KHA responses

AKERS DR & ACCESS RD ROUNDABOUT CONSTRUCTION DOCUMENTS

CITY OF COLORADO SPRINGS, COUNTY OF EL PASO, STATE OF COLORADO

AKERS DR & ACCESS ROAD ROUNDABOUT
EL PASO COUNTY, COLORADO
ROADWAY CONSTRUCTION DOCUMENTS
COVER SHEET

TRUCK APRON DETAIL  
(N.T.S)

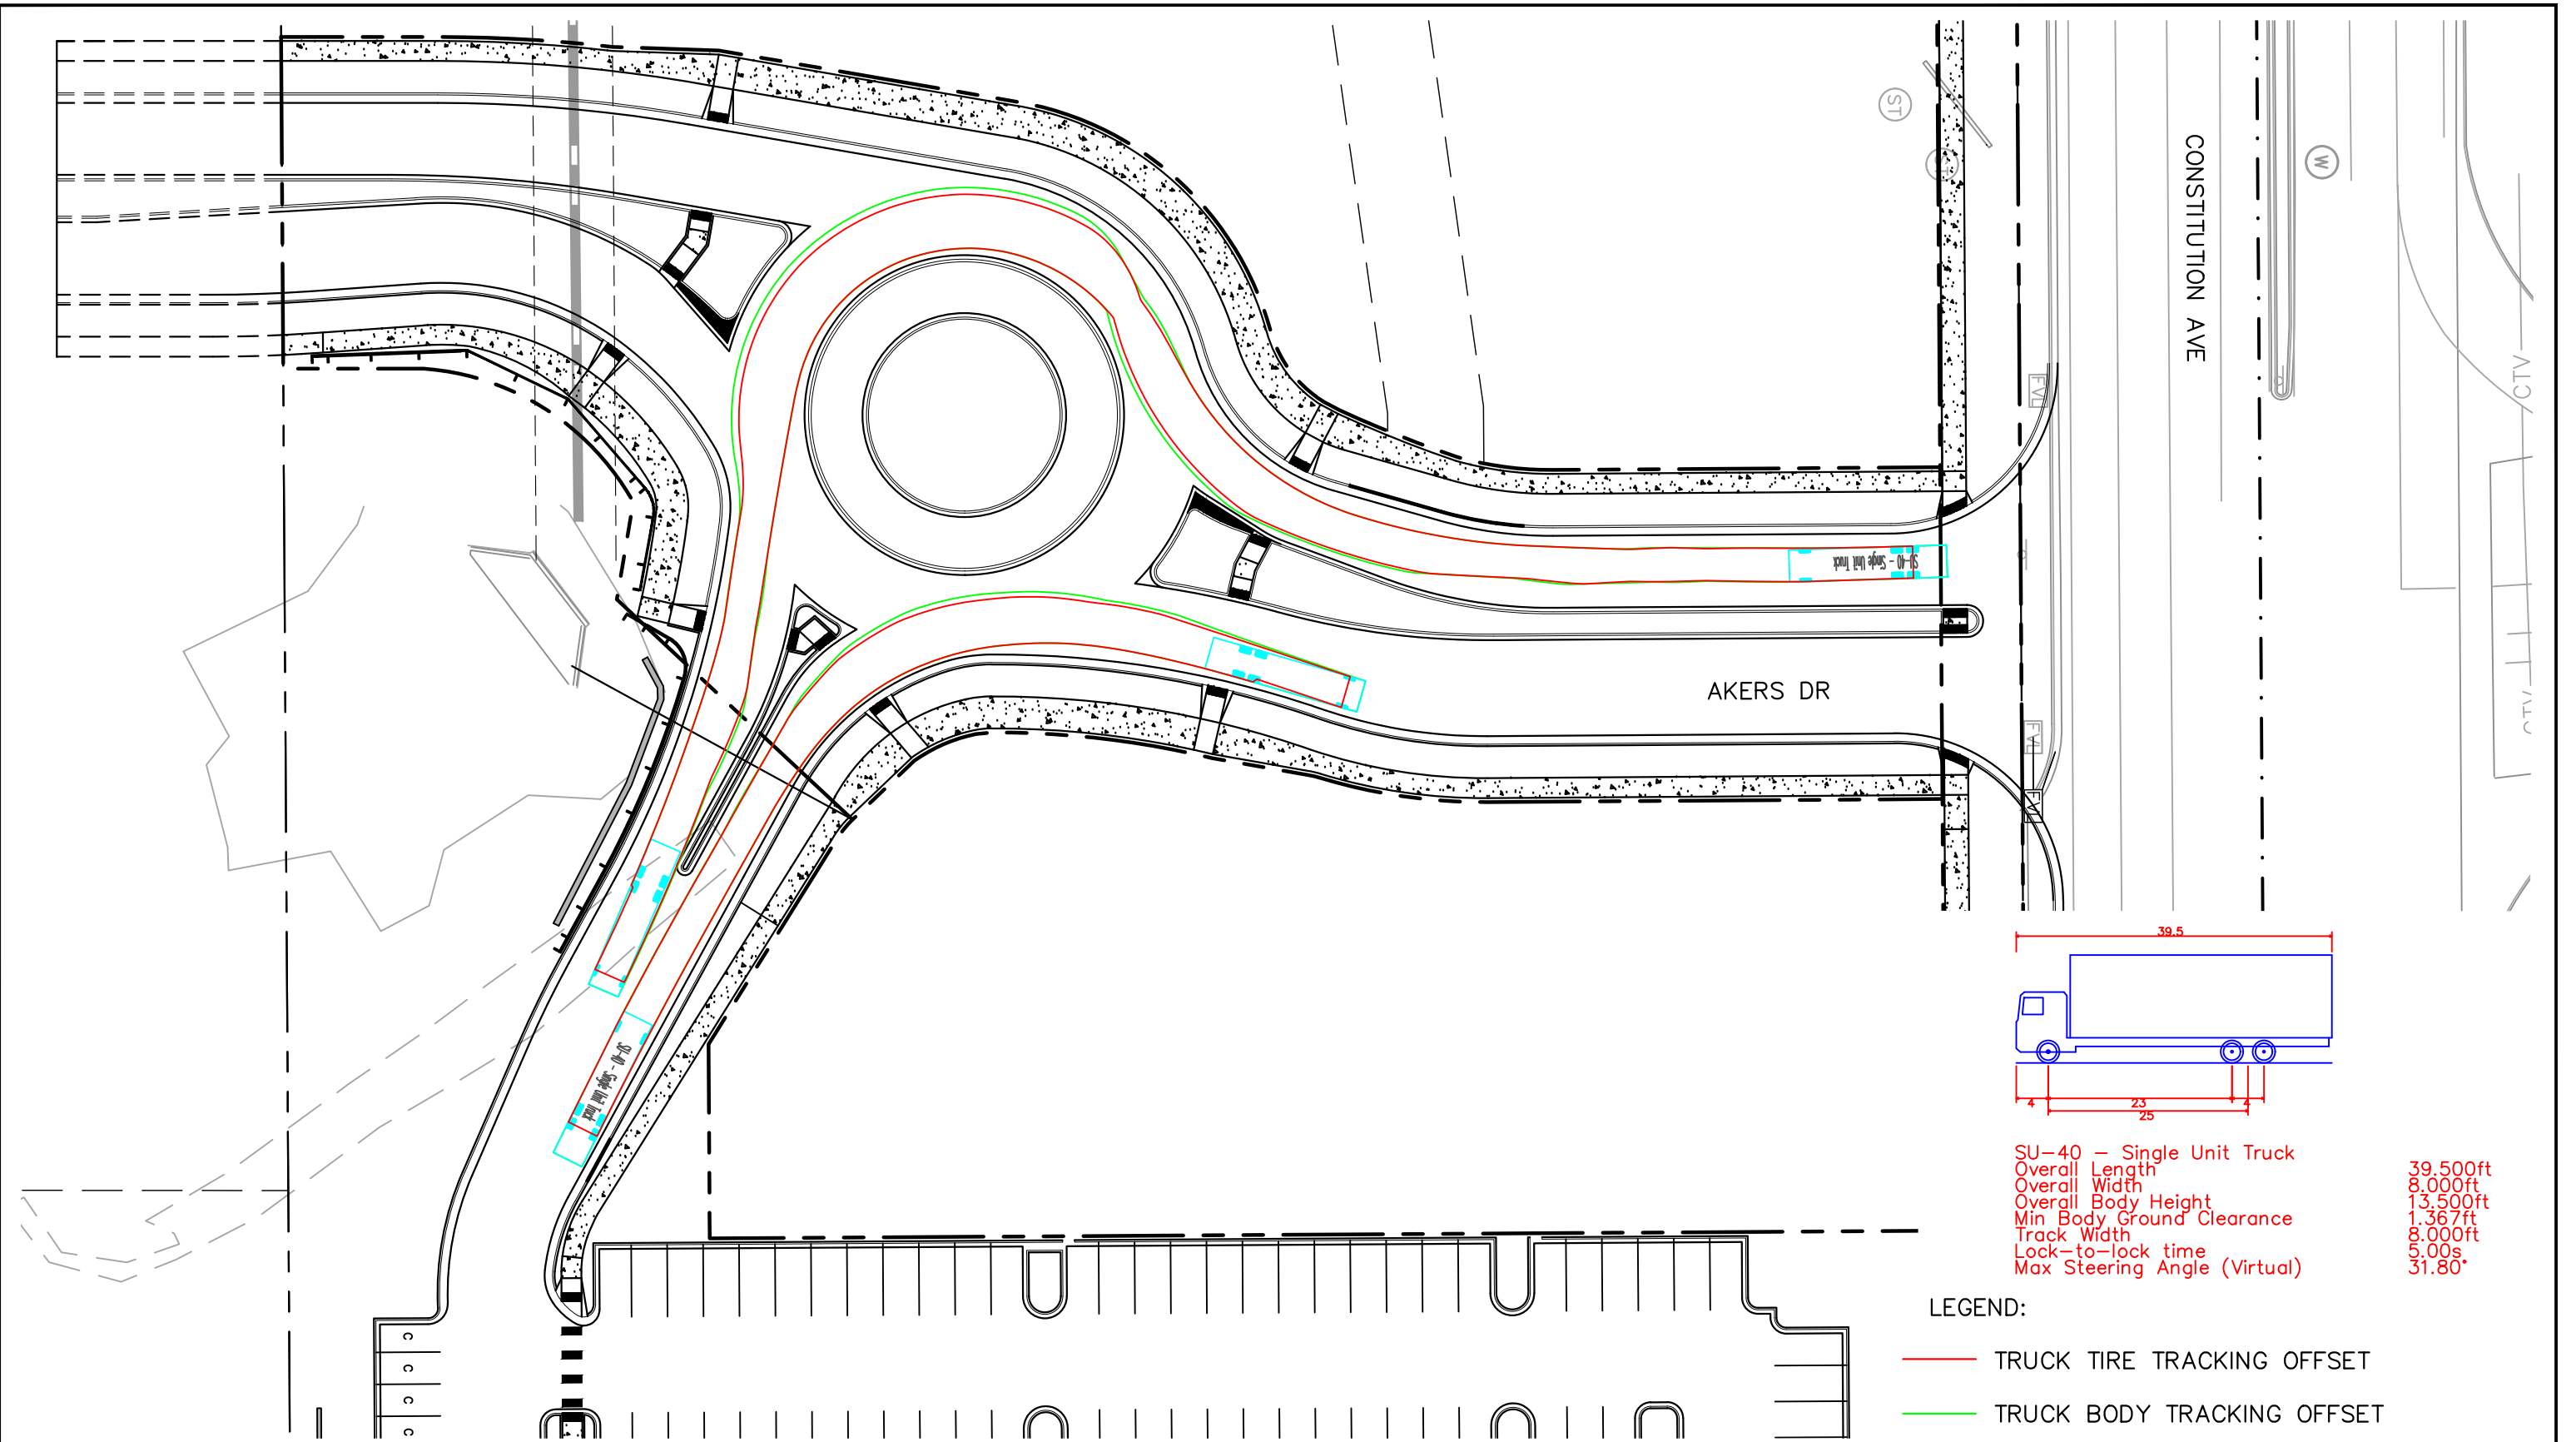
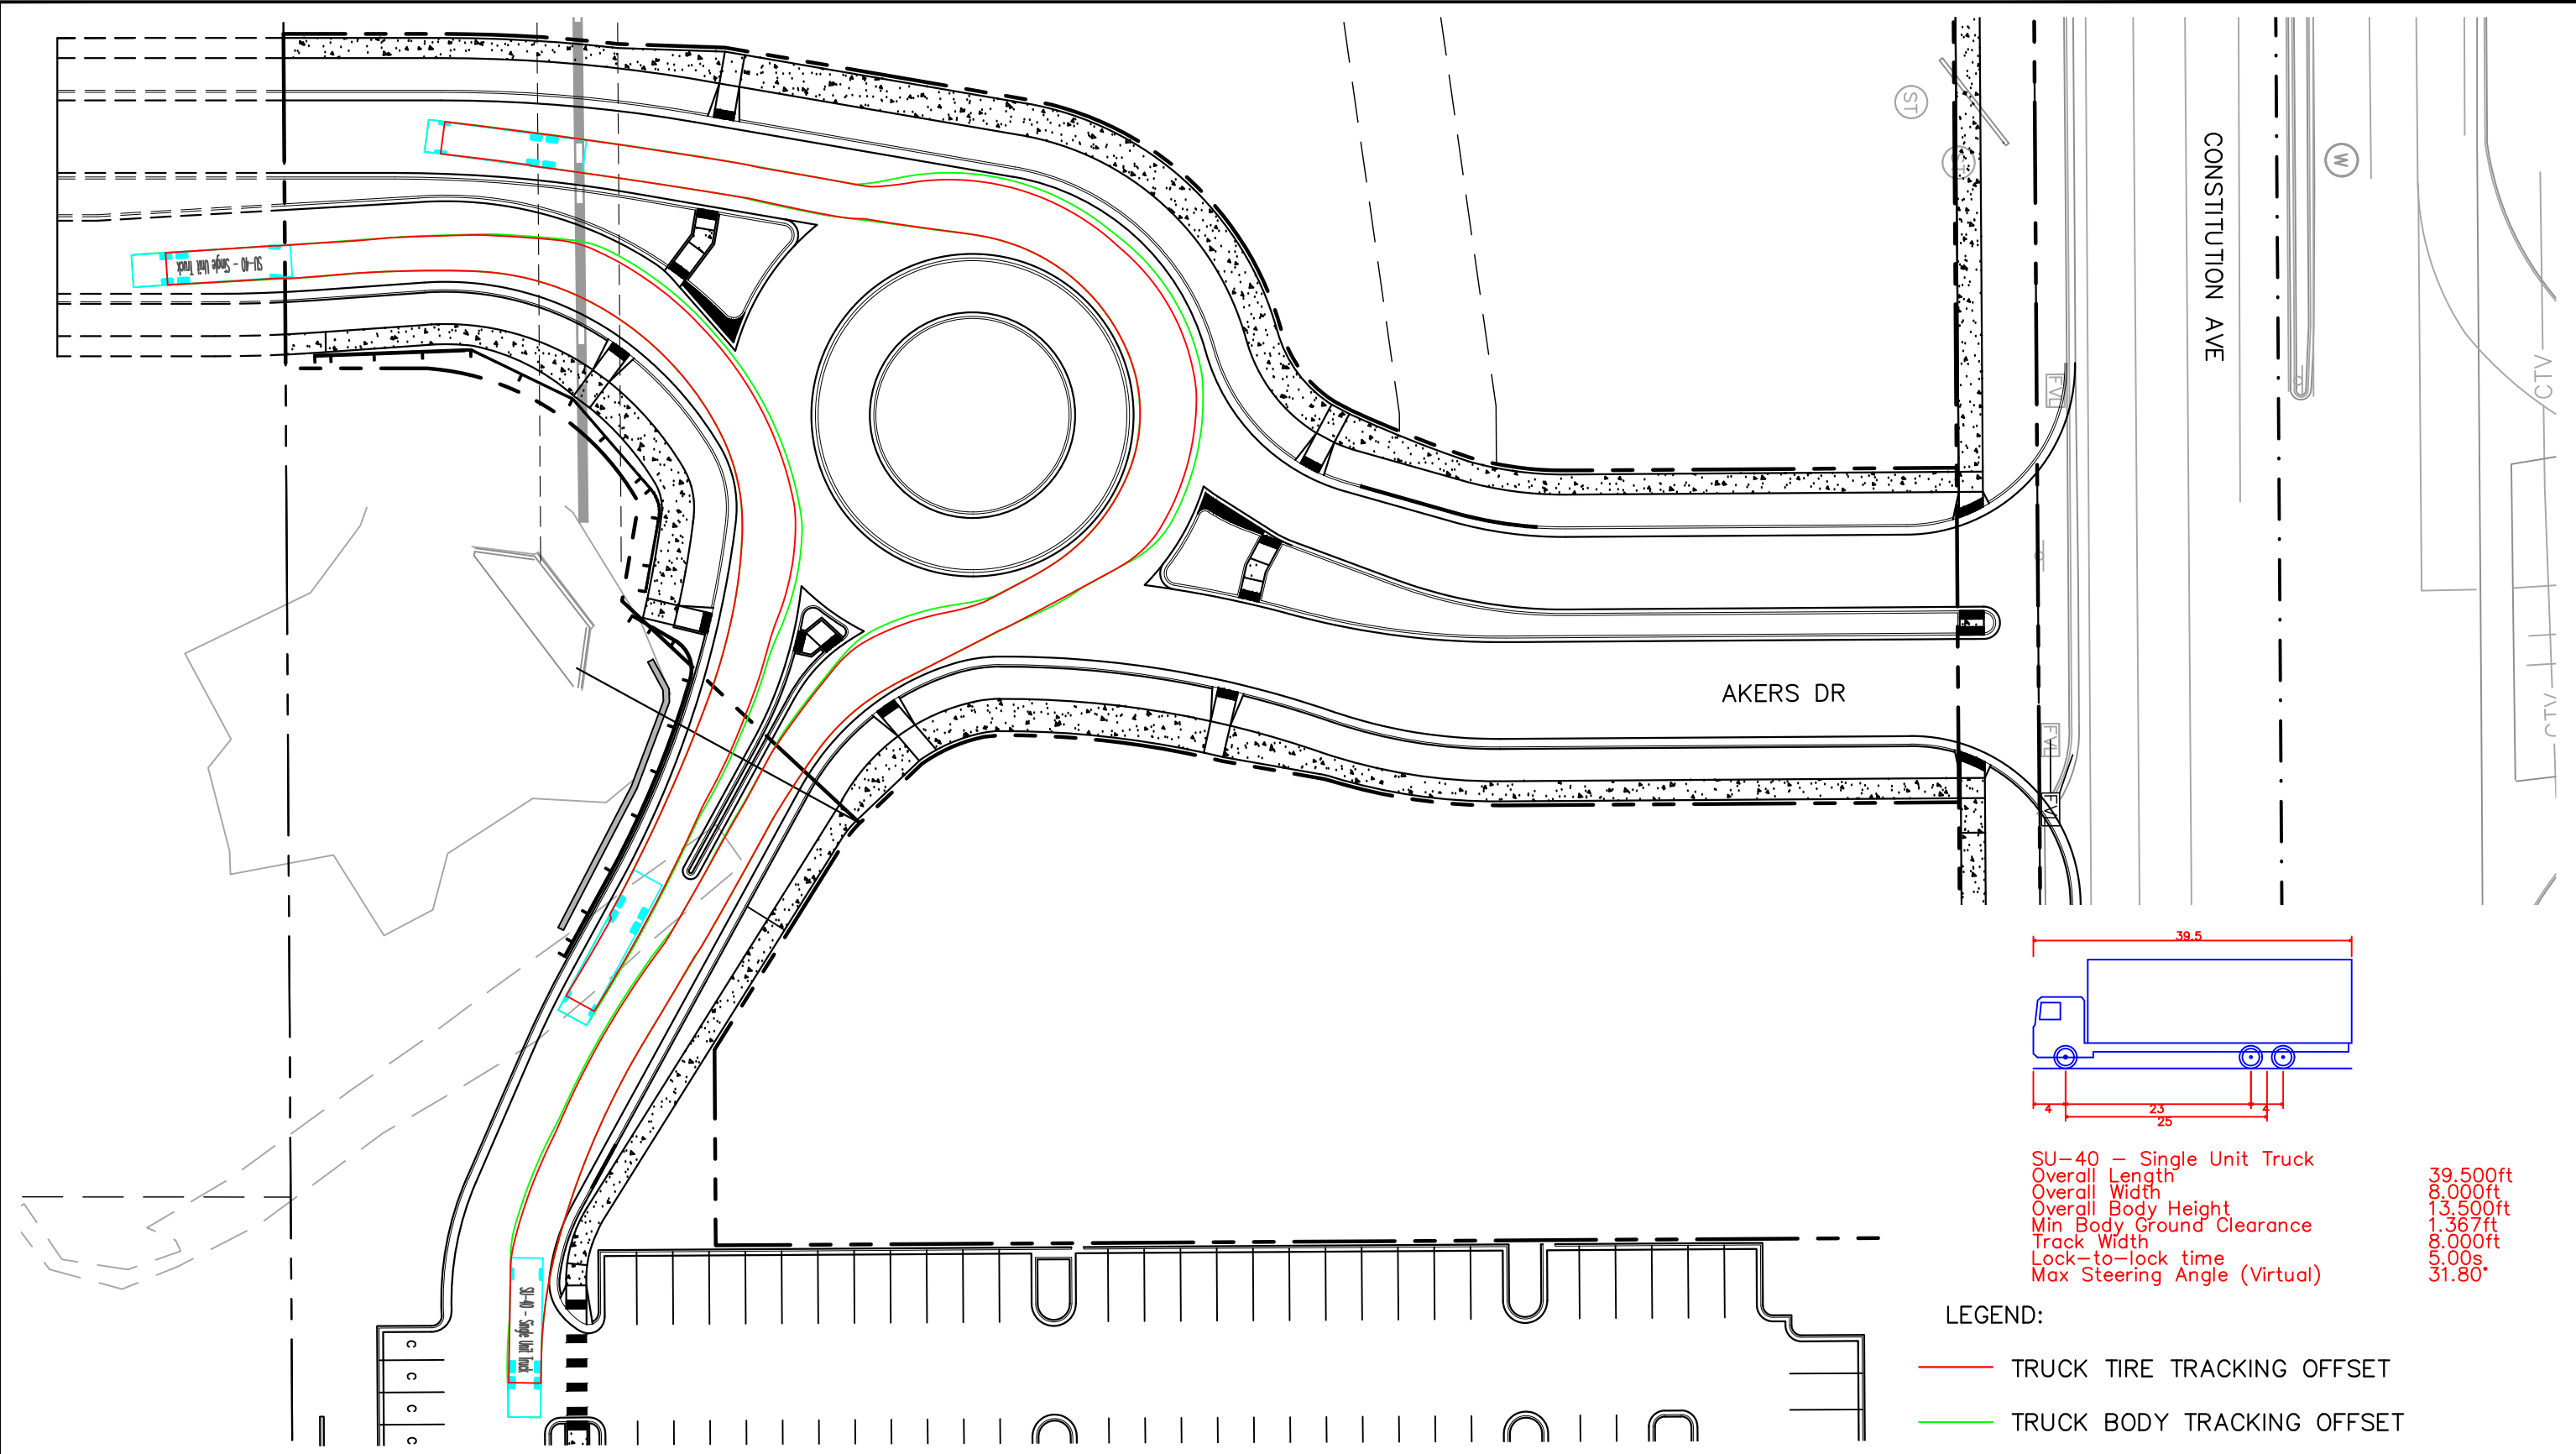
Please revise the apron detail as a 2.5' tall curb would not be supported. Please refer to Lorson Ranch project for truck apron example and other roundabout details/examples (PCD project file no. CDR183 pg 27-29, <https://epcdevplanreview.com/Public/ProjectDetails/102862>)

Apron detail revised to be consistent with the Lorson Ranch roundabout

4

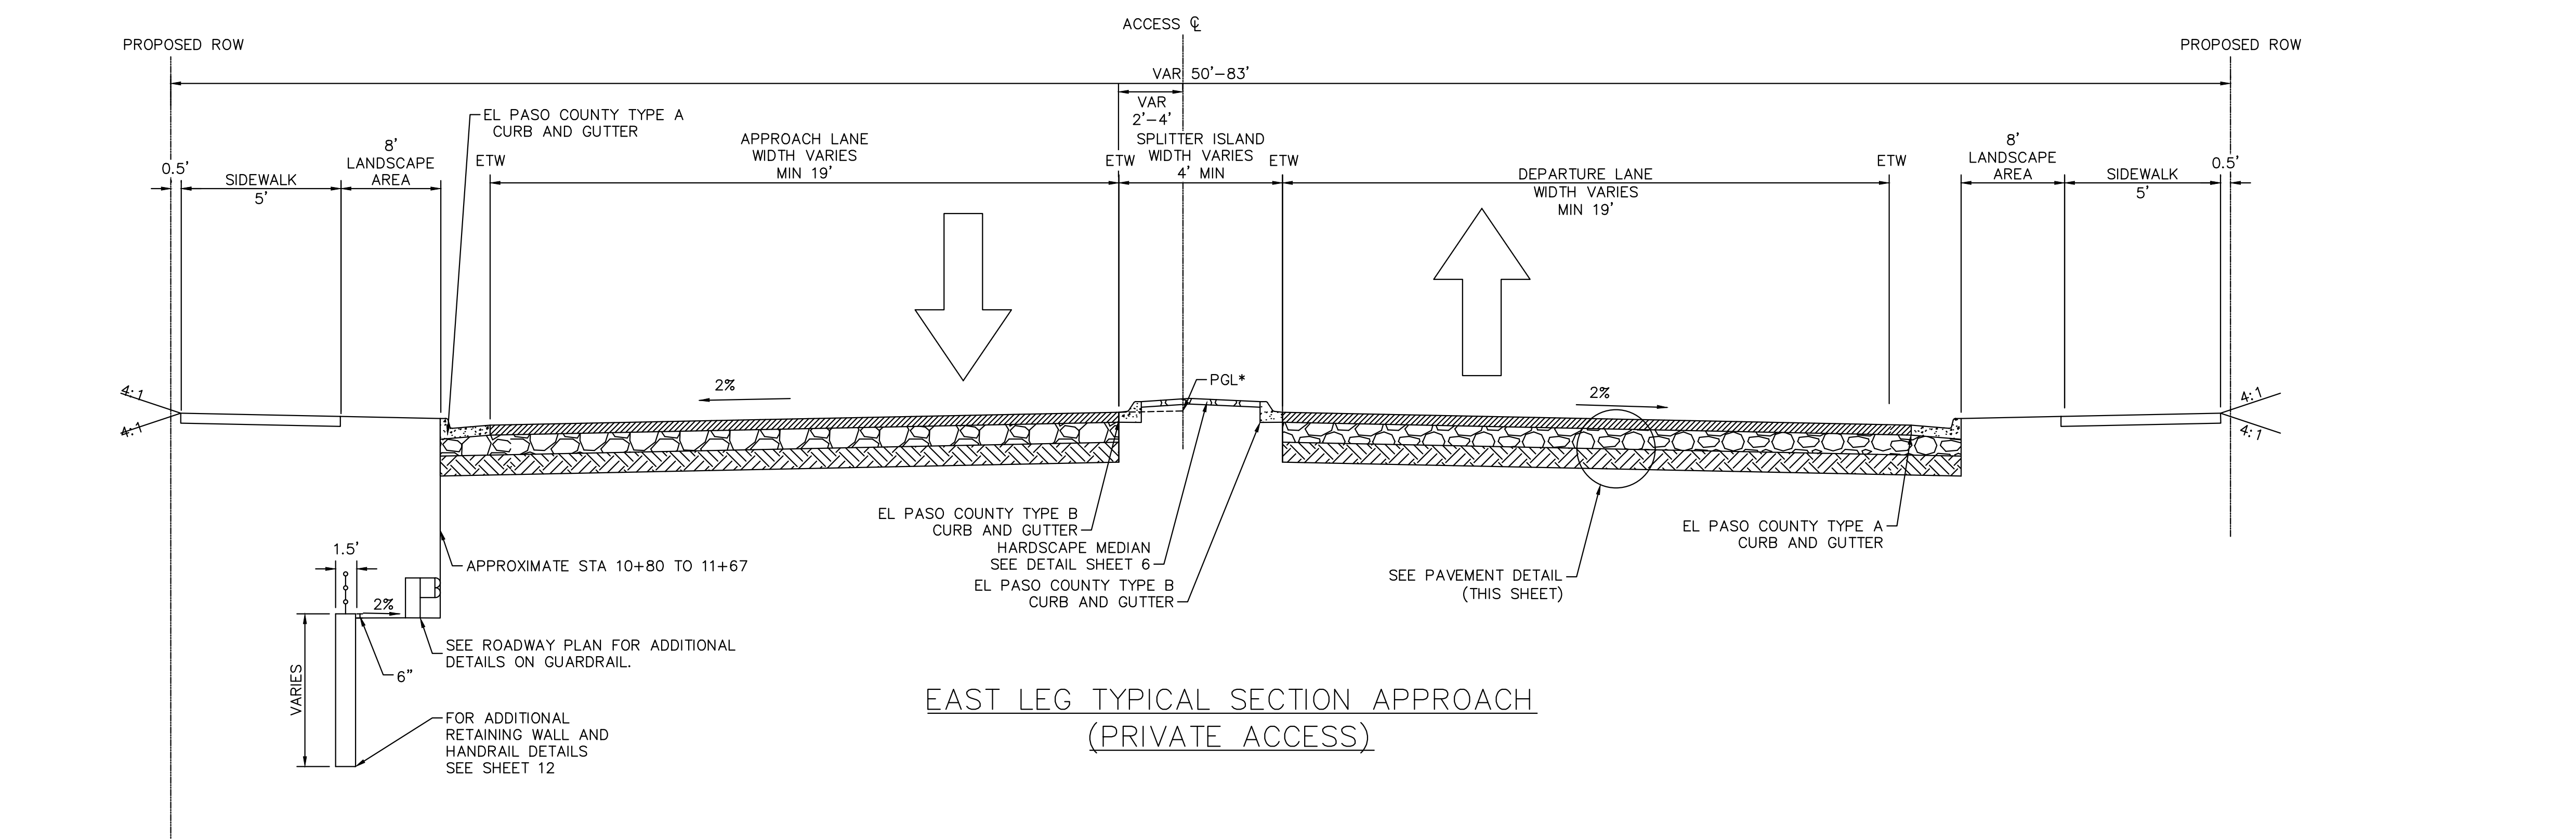
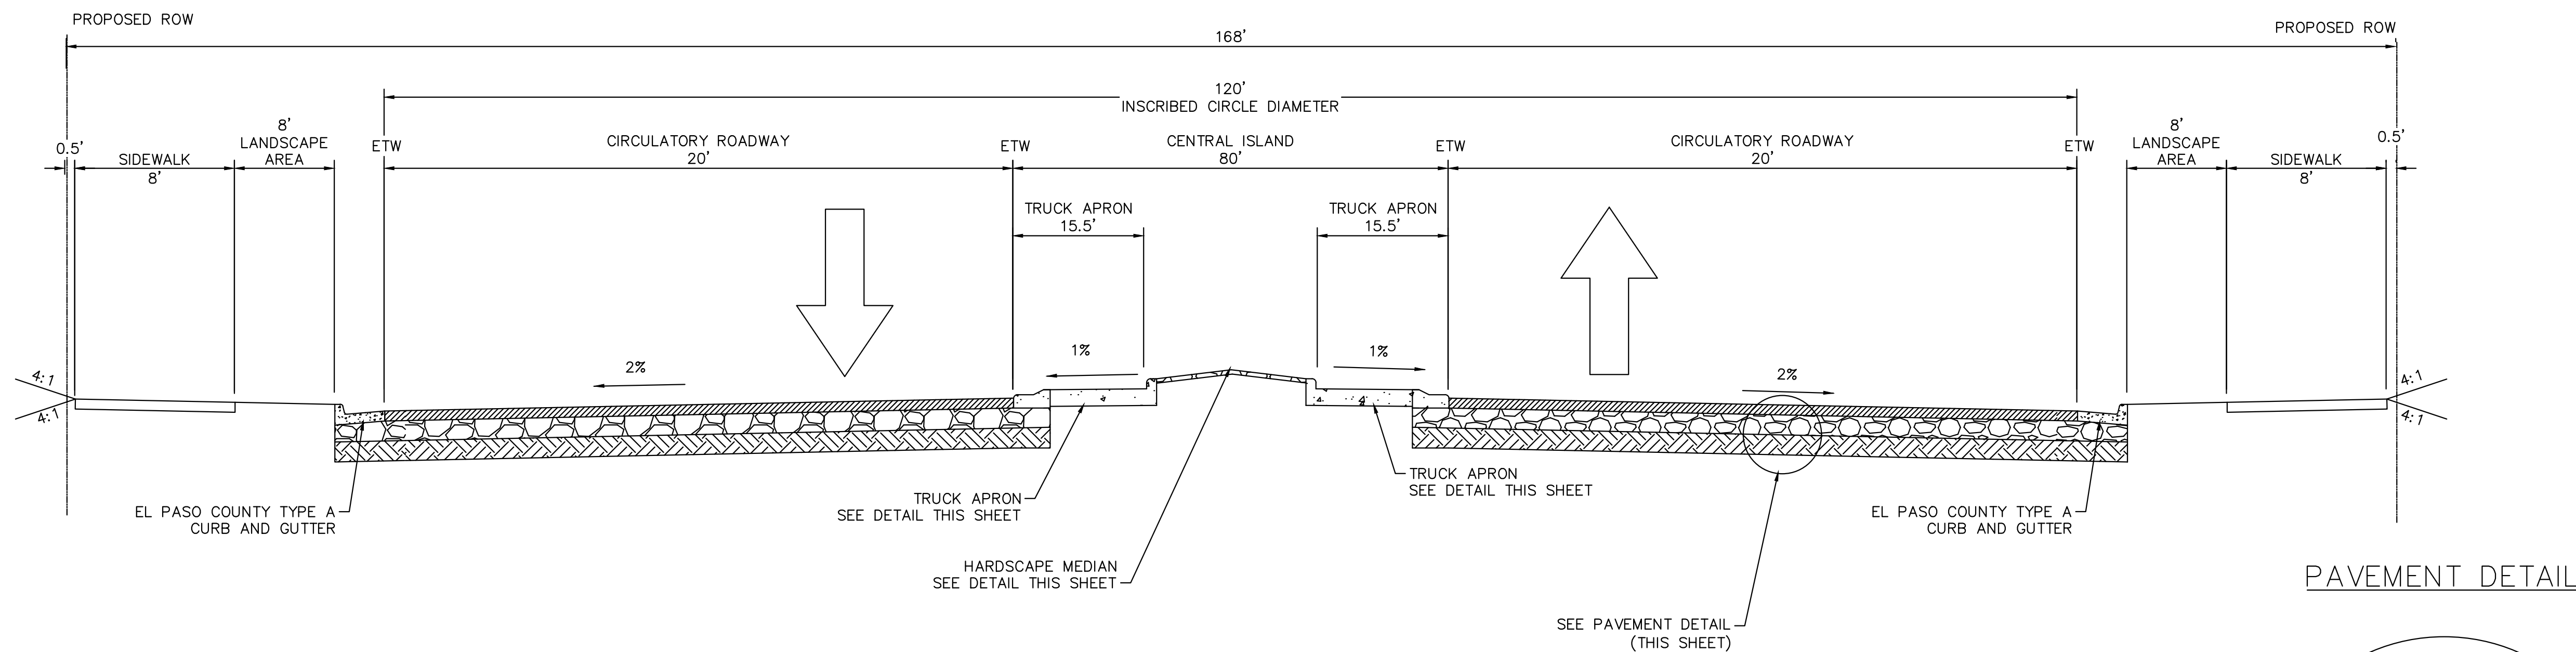
Provide sidewalk on the west side of the roadway

Please provide an abbreviations list or spell this out.

Provide ROW length

Please delete. Median shall be patterned concrete per detail SD_2-21. Please indicate this on the cross-section

per the the plans it appears that this should be 6' min. as the curb and gutters alone account for 3'. Revise accordingly

sidewalk provided on west side of roadway

Abbreviations list provided

ROW width labeled

Median treatment revised to show patterned concrete per SD_2-21

Median minimum width revised on typical
